CDS Planning and Development Consultancy

11th March 2026

Planning Application
44 Murray Road, Northwood, HA6 2YL
Planning Application 1787/APP/2025/1849

Please find attached the Formal Amendments for Planning Application 1787/APP/2025/1849, prepared following extensive and positive discussions with the Council across two meetings.

Drawing Number	24 / 3555 / 12	Revision	A
Date	12 / 12 / 25		
Scale	1:200 @ A1

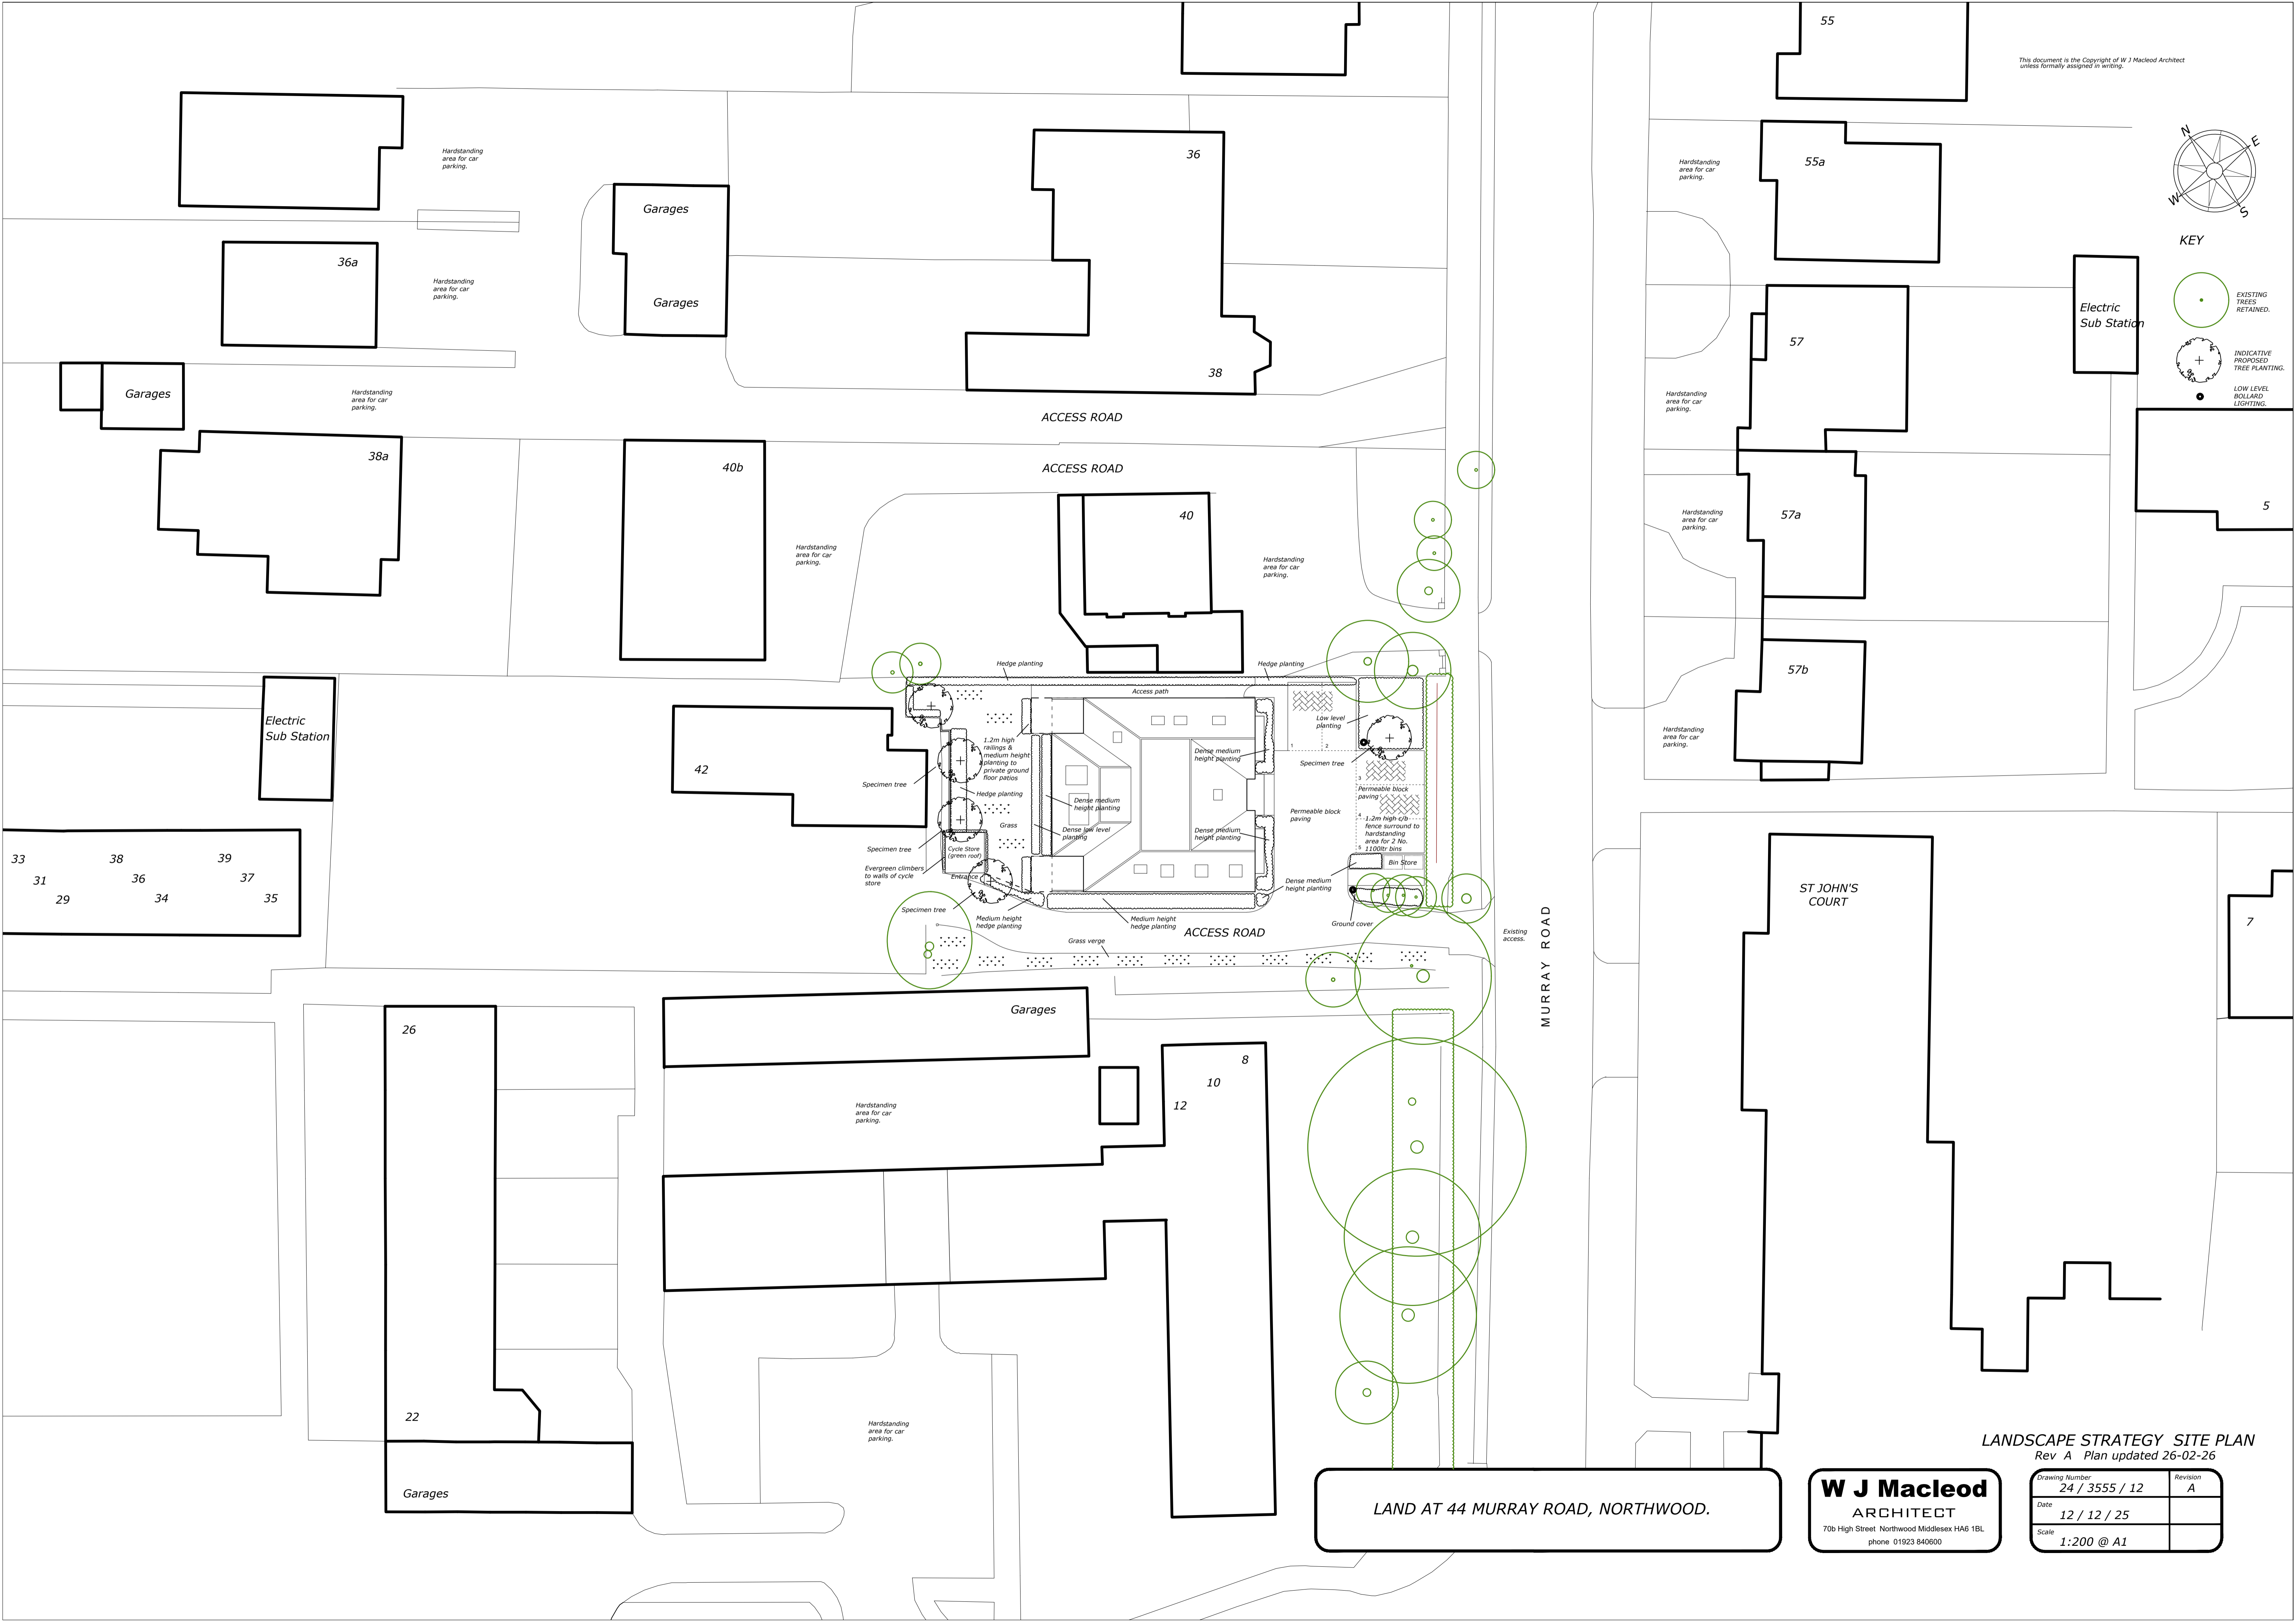
Concerns were raised regarding the reduction in soft landscaping to the site frontage.

The revised retains the existing hedge, and the parking arrangement has been rationalised to allow for increased soft landscaping. Ancillary structures have been relocated away from the primary landscaping areas, enabling the introduction of more substantial and visible planting that will enhance the site when viewed both from Rickmansworth Road and on approach to the site.

A landscaping plan has been prepared to demonstrate the quality, functionality and long-term viability of the external spaces. As part of this submission, a Landscape Master Plan prepared by ACD Landscape Architects has been provided which illustrates the significant enhancement to the site's external environment.

Floor Plans and Elevations

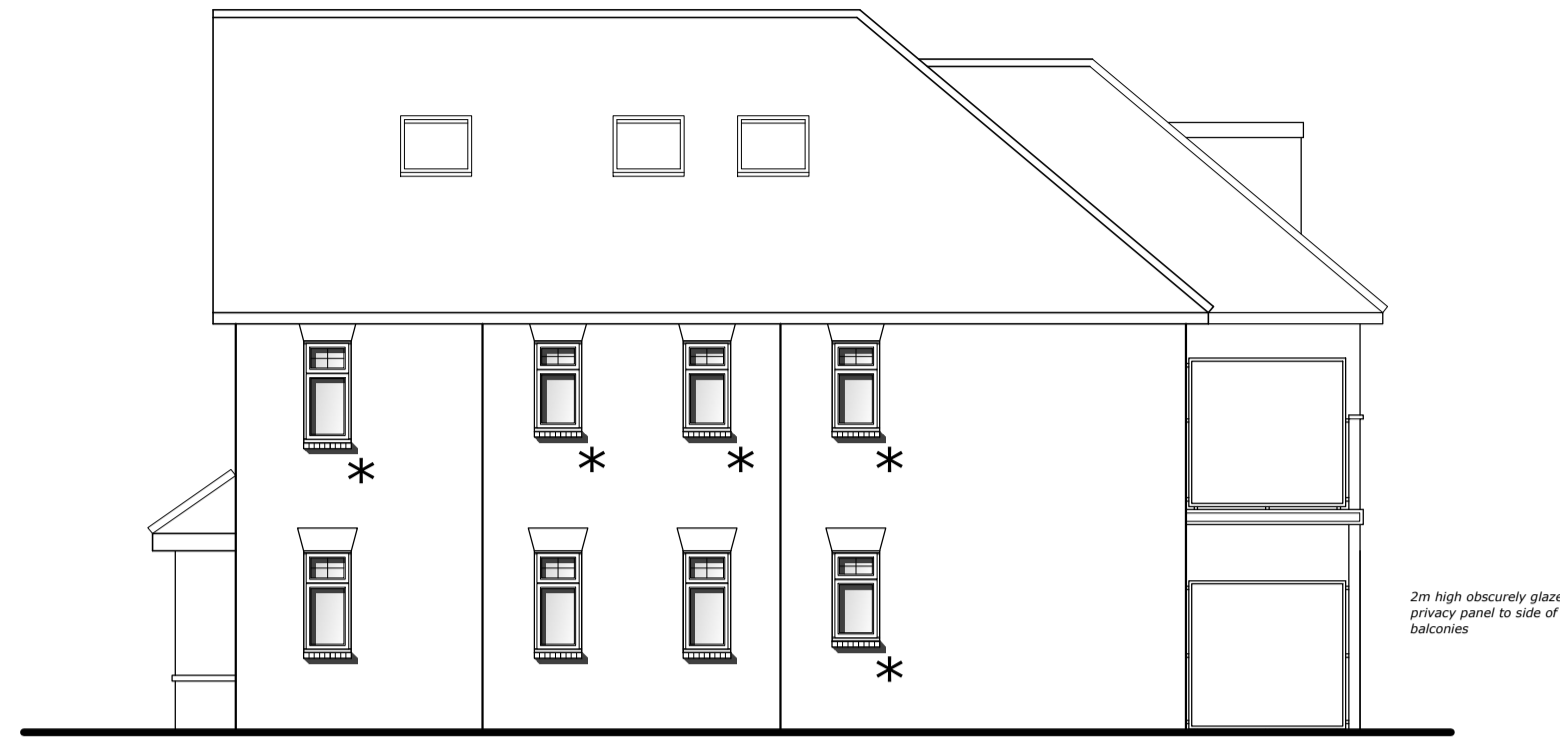
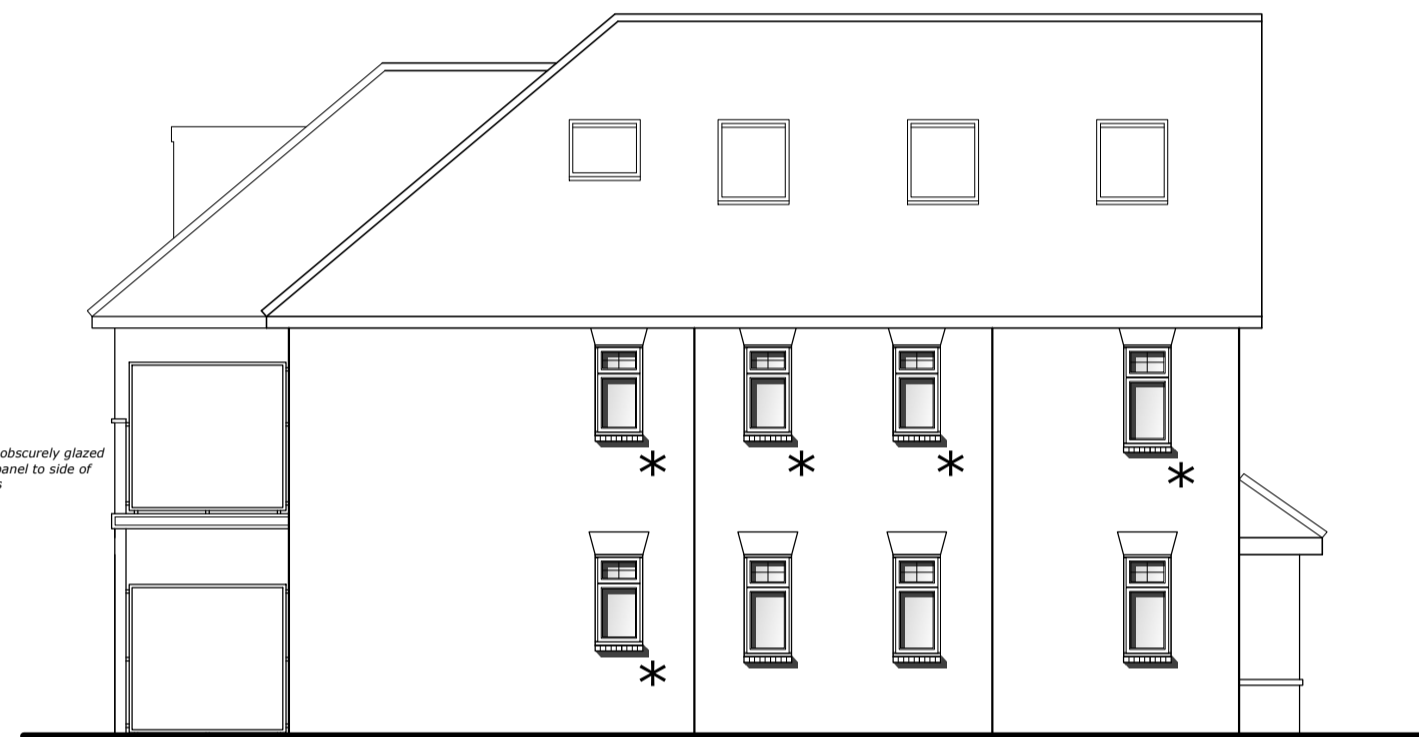
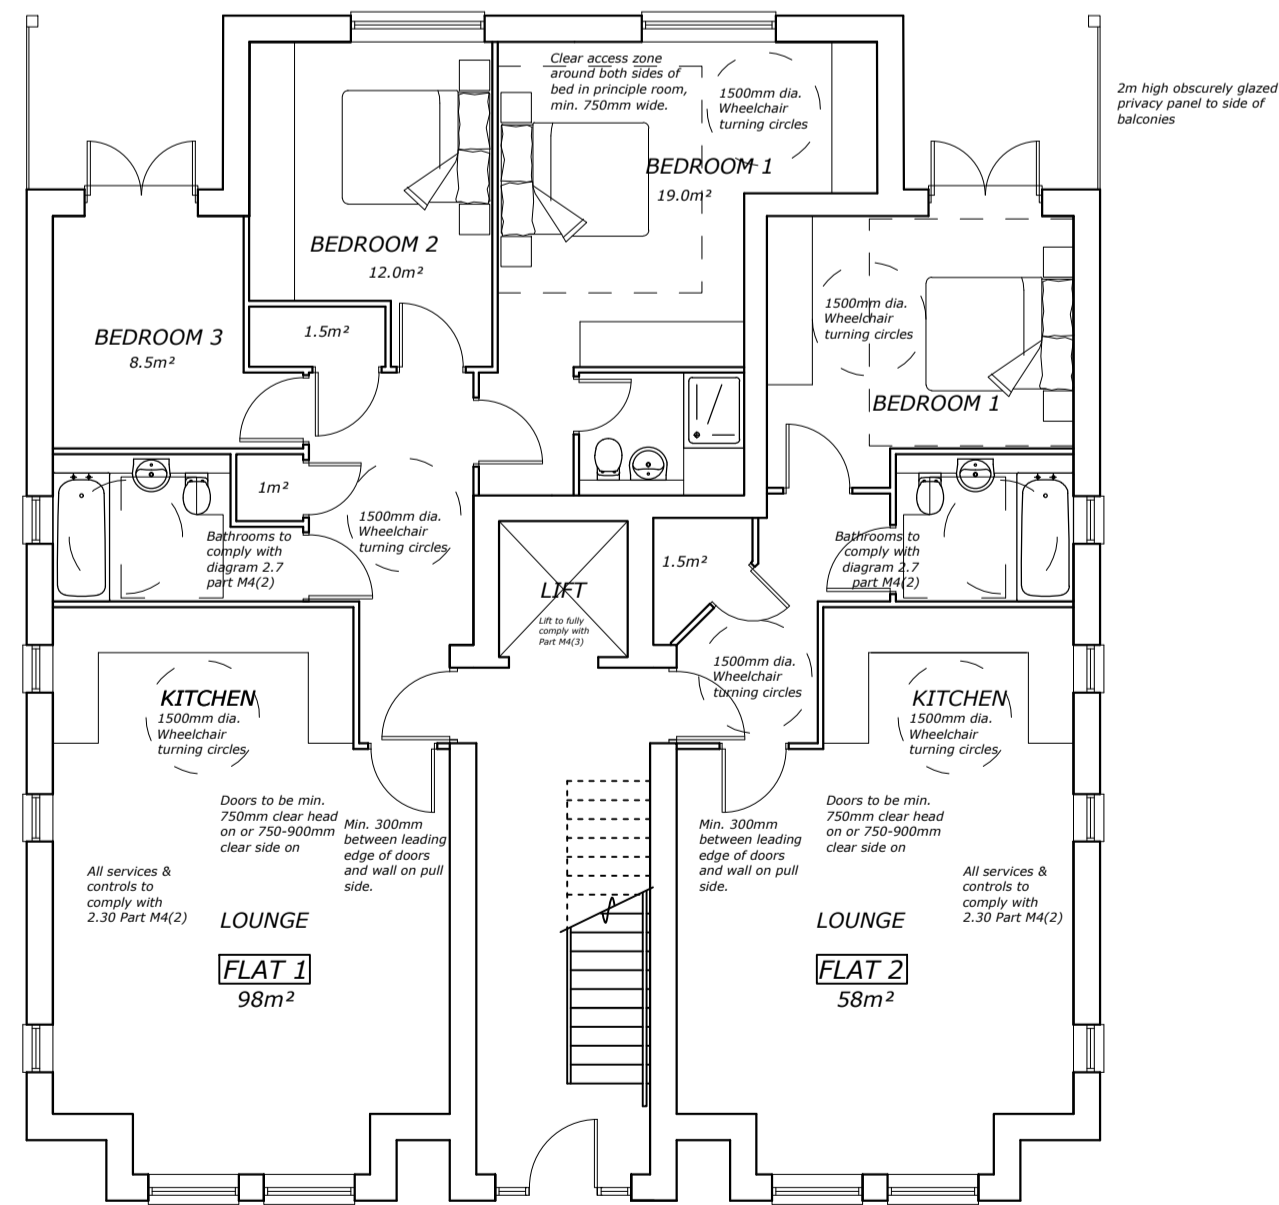
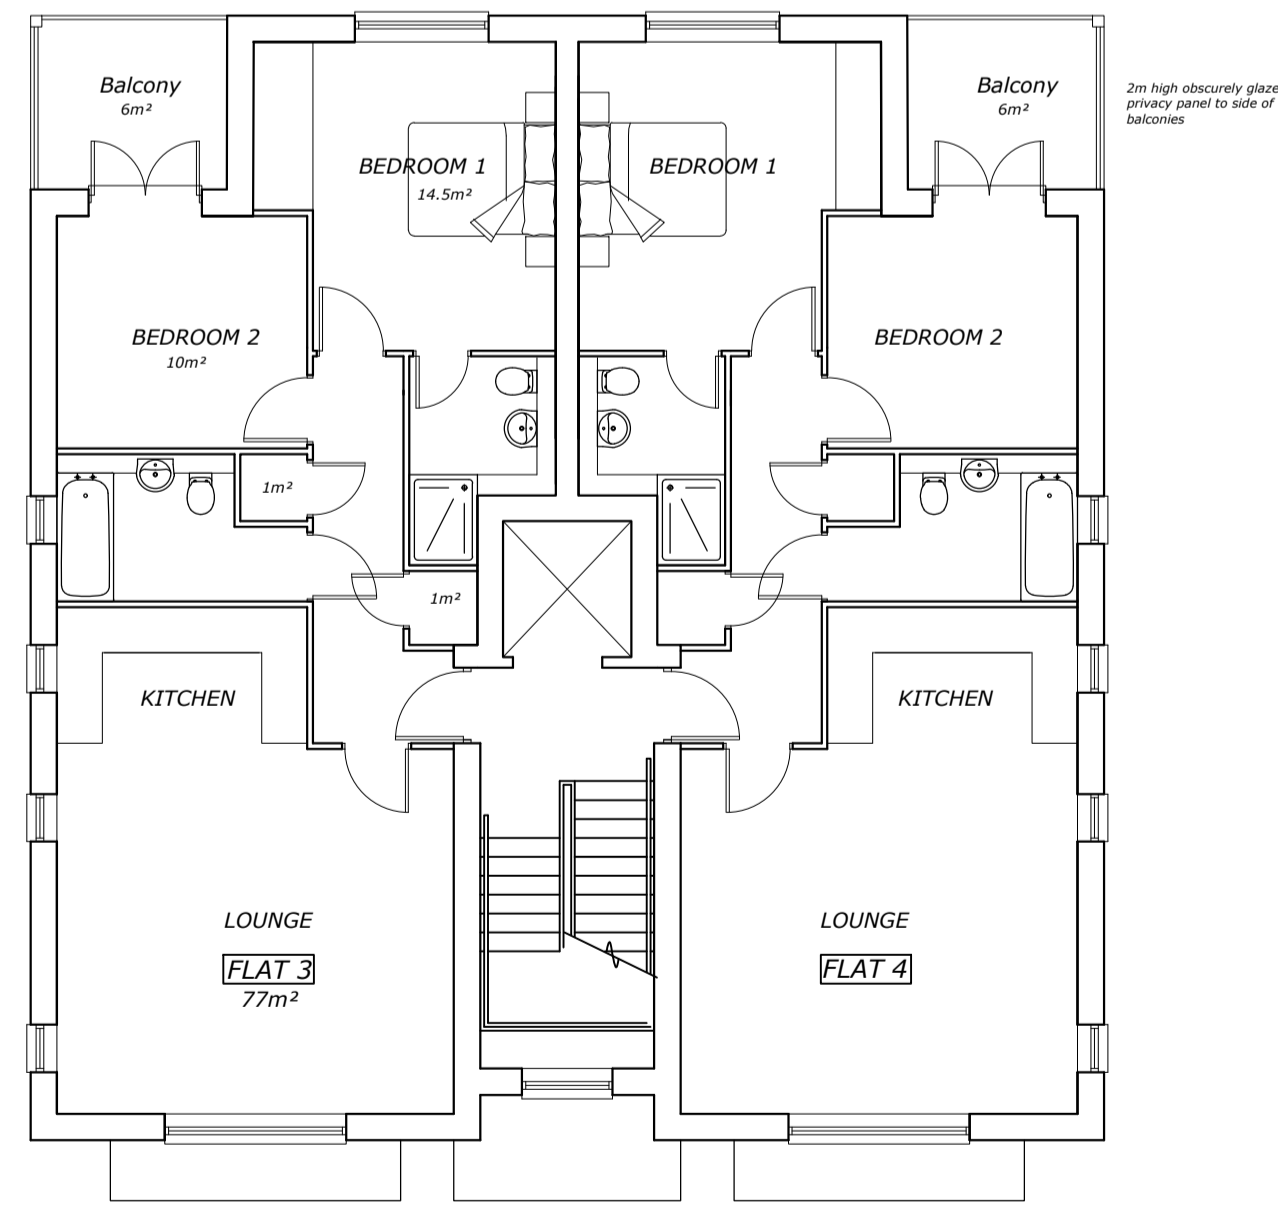
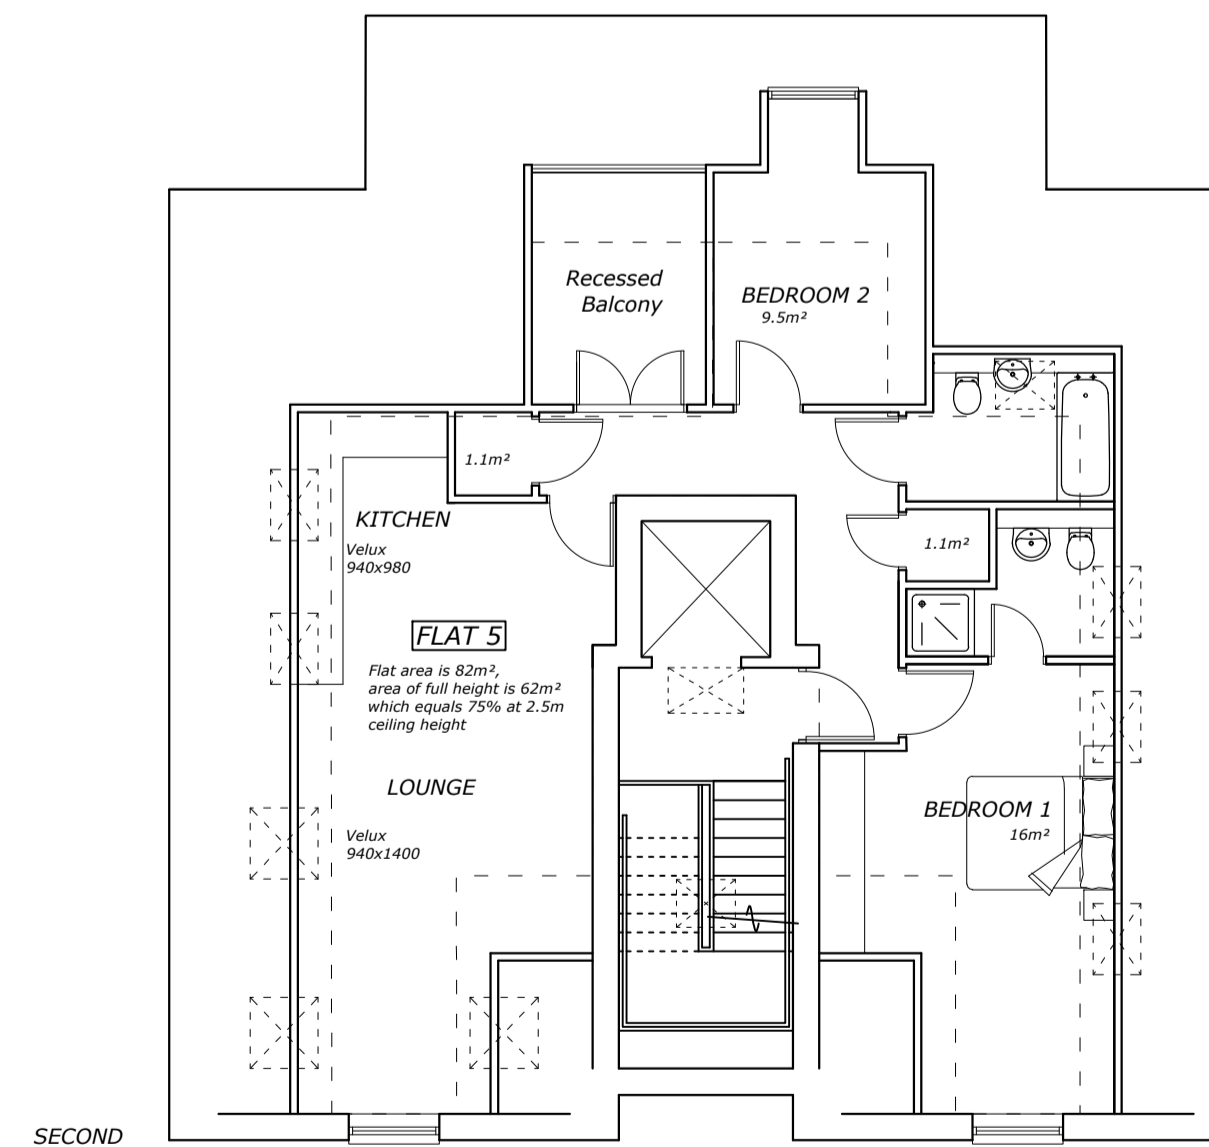
Concerns were raised that the architecture appeared overly complex within the context of the street.

Officers also raised concerns regarding the projecting bay features. These have now been omitted entirely. The revised design adopts more traditional window and door arrangements, with improved vertical alignment across floors and a clear and respectful window hierarchy.

In response, the design has been simplified while retaining an appropriate level of architectural interest, ensuring that the building does not appear overly plain within the streetscape. Amendments include a simplified front porch and the removal of front balconies, which the Council considered lead to a somewhat cluttered appearance. The arrangement of windows at ground and first floor level has also been refined so that the building reads more clearly as a single dwelling, helping it sit comfortably within the established character of the area. The overall design now presents a more restrained and classic façade, with fewer projections and recesses.

Officers requested clarification regarding the amenity of the ground floor flats, particularly those with bedrooms facing the communal rear garden.

In response, low-level fencing is now proposed, as shown on the site plan, to define and secure private amenity areas to the rear of Bedrooms 1 and 3 of the ground floor units. In addition, defensible planting and hedging can be introduced to the rear of the bedroom windows to further safeguard privacy. These measures will ensure a high-quality and policy-compliant level of residential amenity for future occupiers and could be secured via planning condition if considered necessary.
